MECKLENBURG COUNTY  
Park and Recreation Department

MEMORANDUM

**DATE:** September 20, 2023

**RE:** Rezoning Petition #2023-080  
PID# 16719249

RZ-1.0

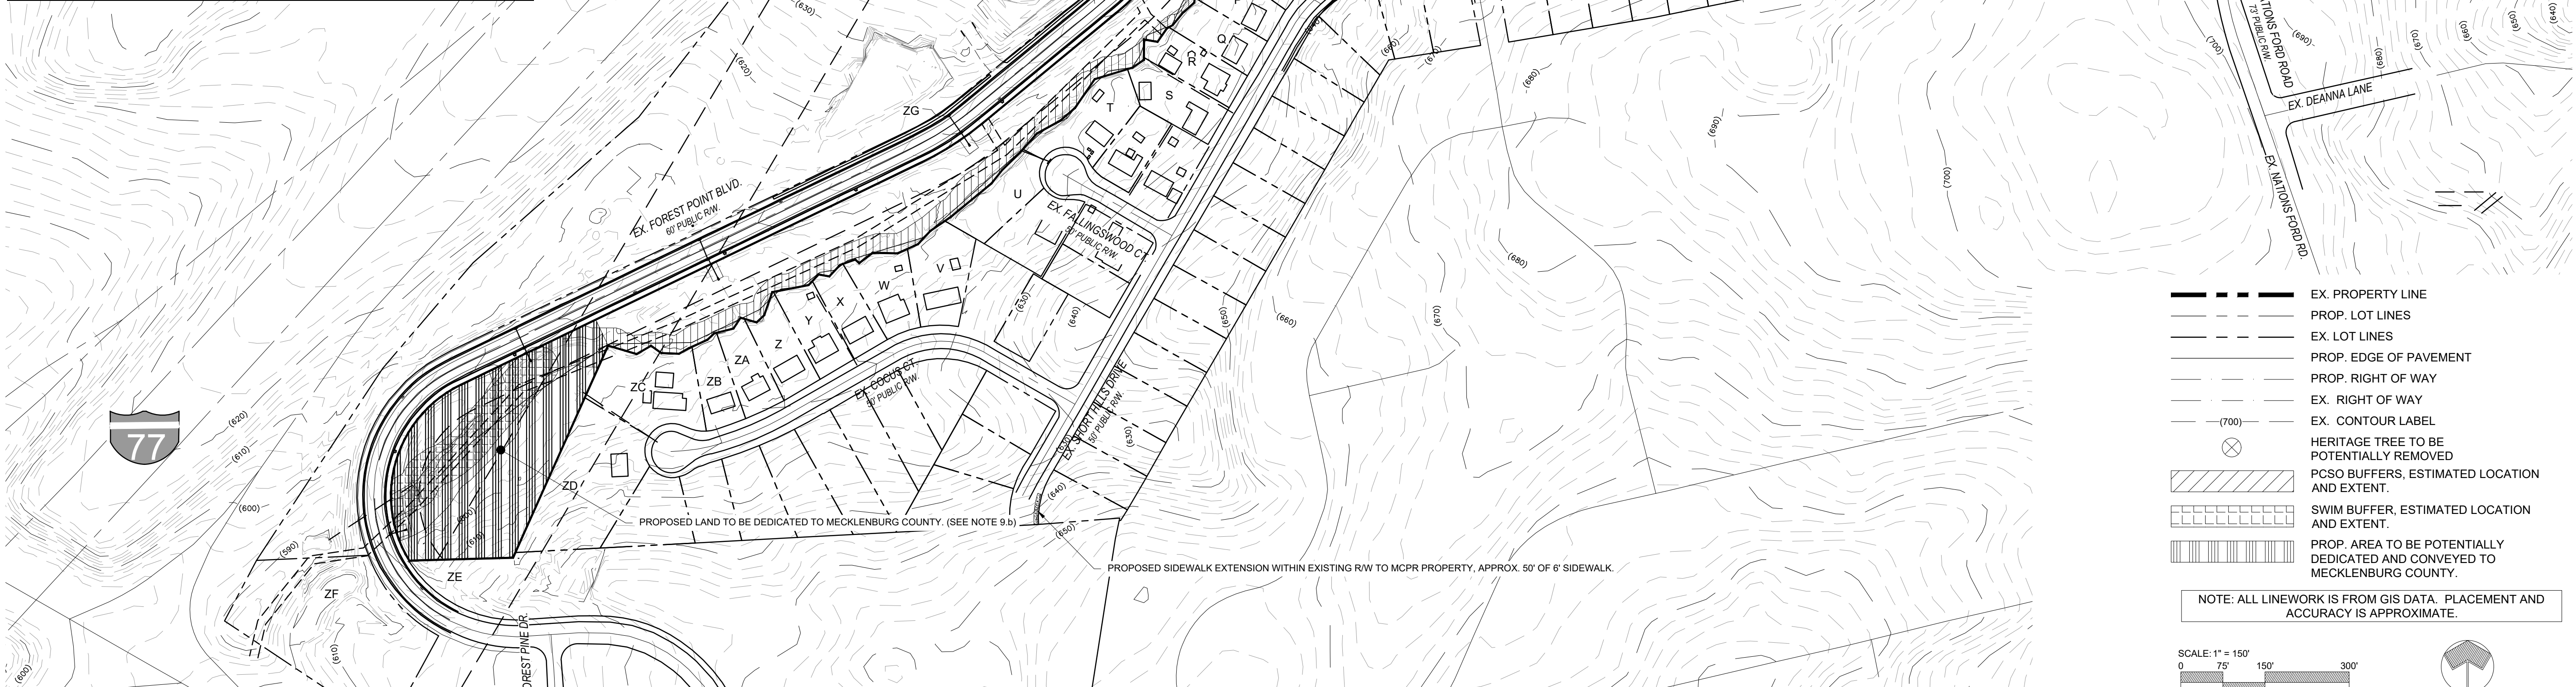
Also, change park dedication notes read: "Proposed area to be potentially dedicated and conveyed to Mecklenburg County."

RZ-2.0

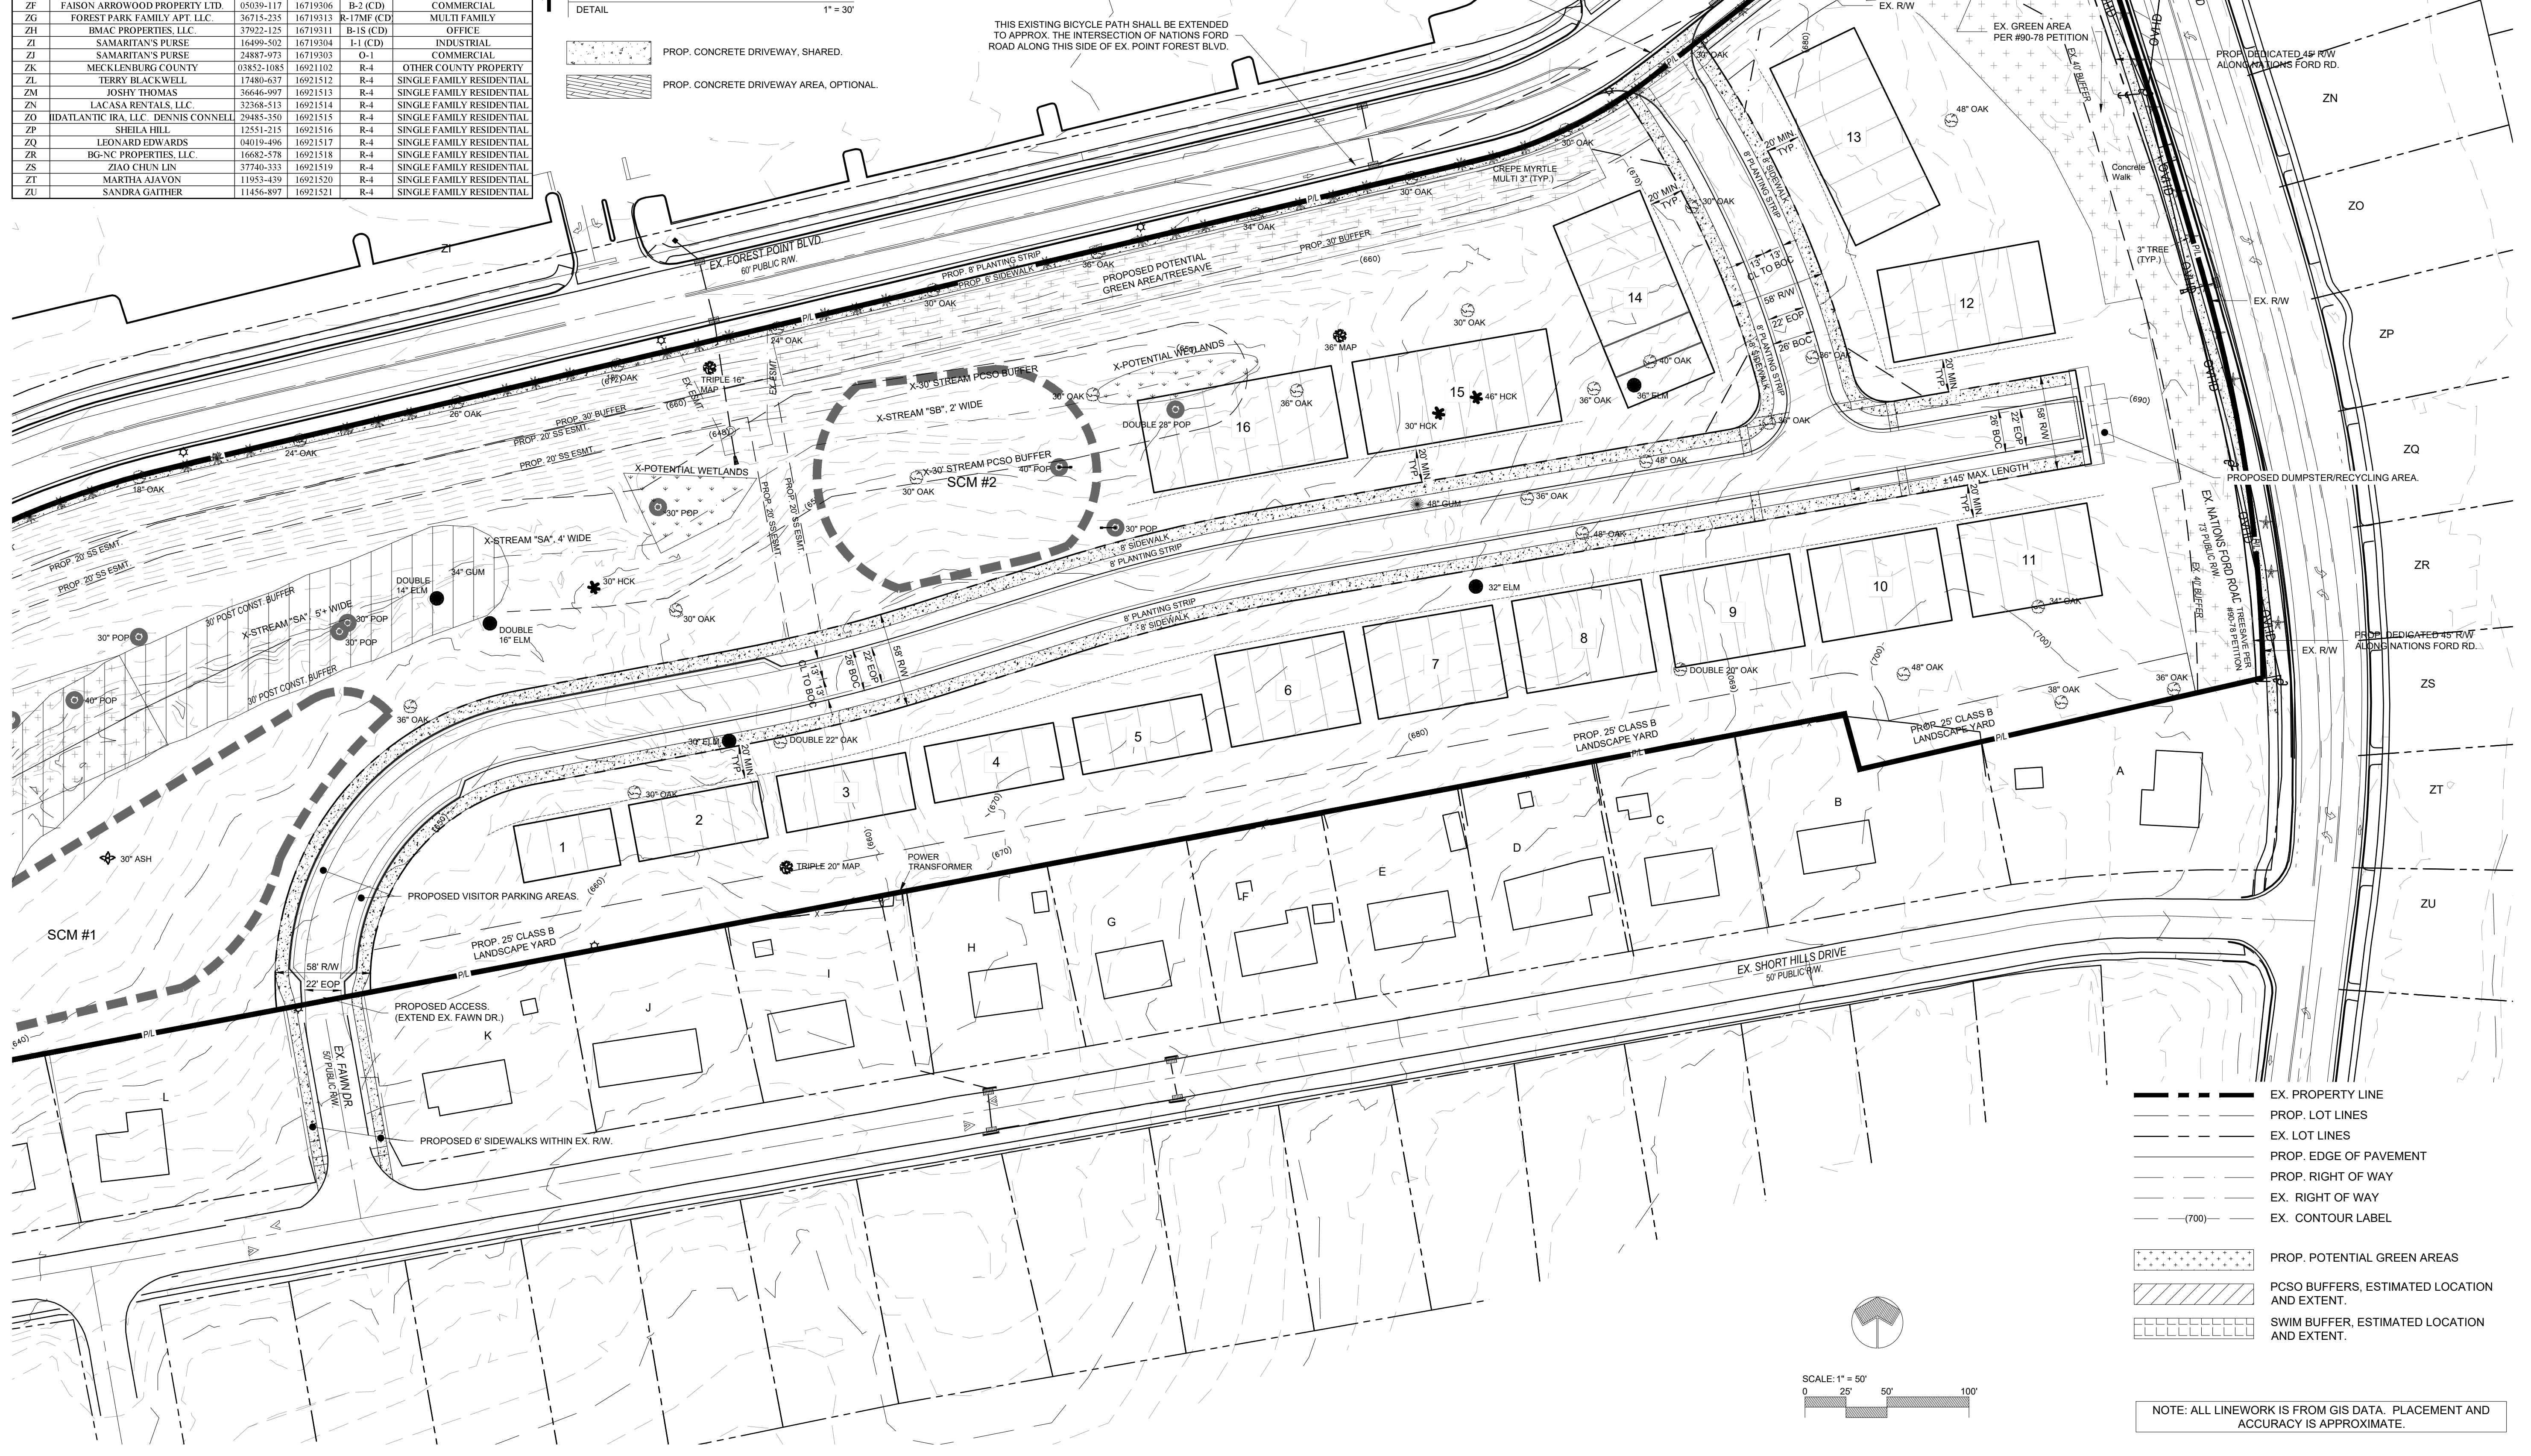
Please provide pedestrian access from the development to the future MCPR Forest Point Park (PID 16719101) along Forrest Point Blvd.
